Please ask for: Ms Iqraa Malik
Email: iqraa.malik@terraquest.co.uk
Telephone: 01212341390
Our Ref: WA/51/21/HH
Your Ref:
Date: 7th June 2021

Application for Planning Permission for Works or Extension to a Dwelling

Development: Erection of single storey rear extension, open porch, part garage conversion and full flat roof re-roofing along with internal alterations
Location: 5 North Pound Walberton BN18 0PZ

BLOCK / SITE PLAN
SCALE 1 : 500

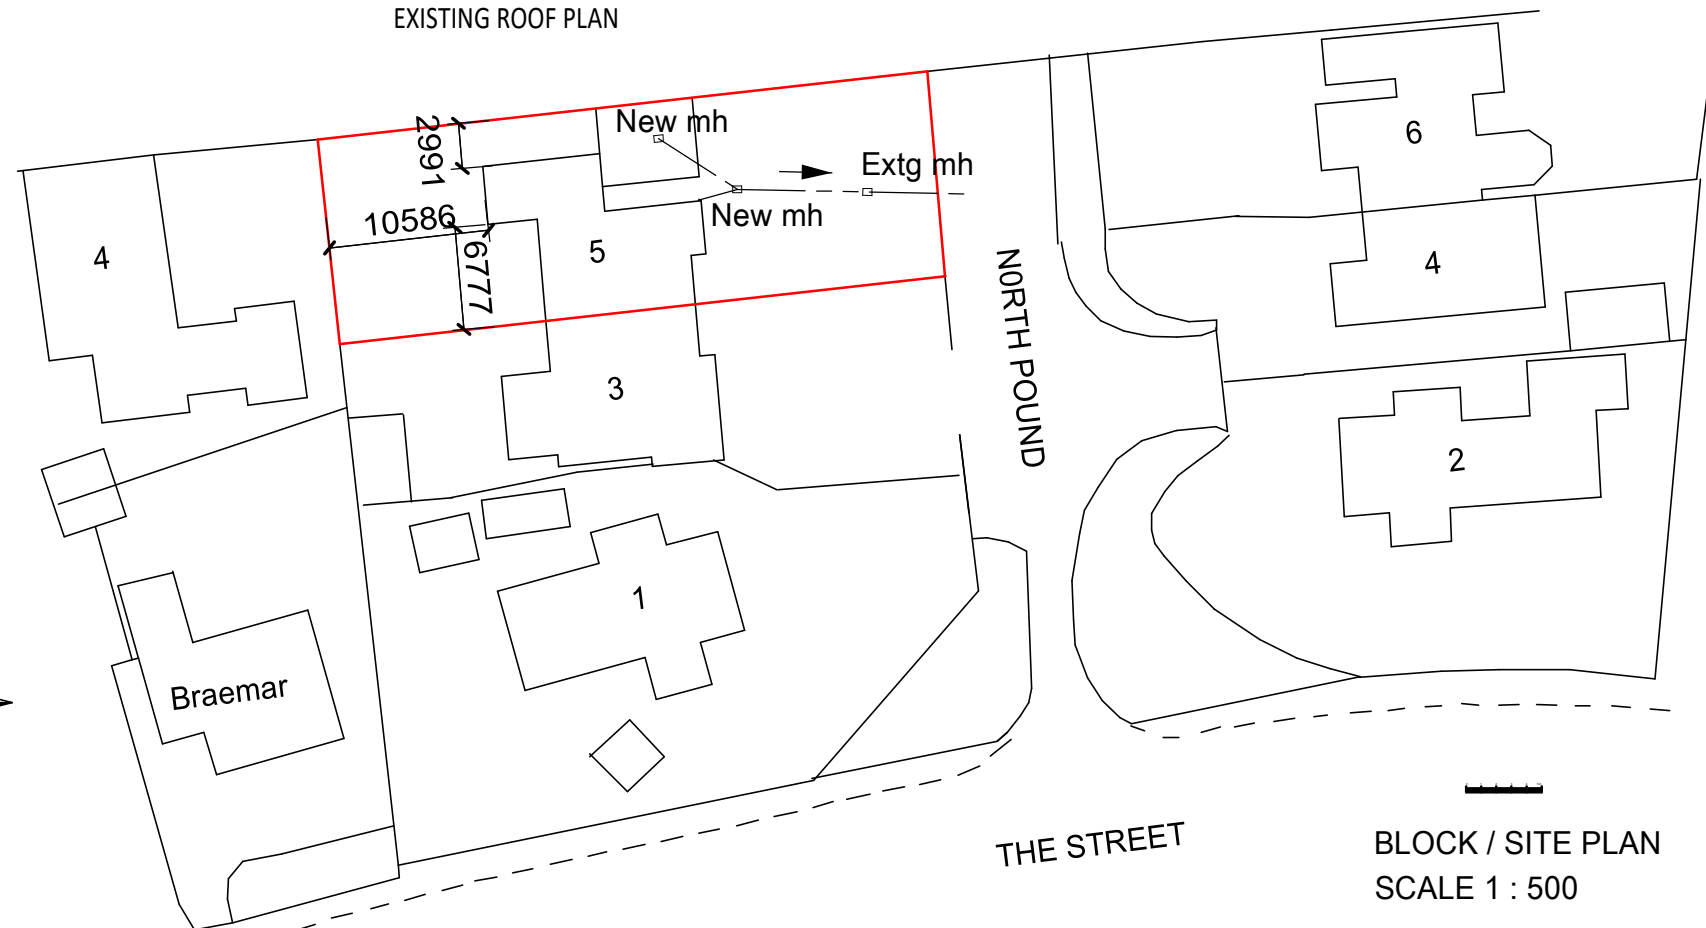
Block Plan

You are required to have dimensions from the proposed extension(s) to all site boundaries. Please amend
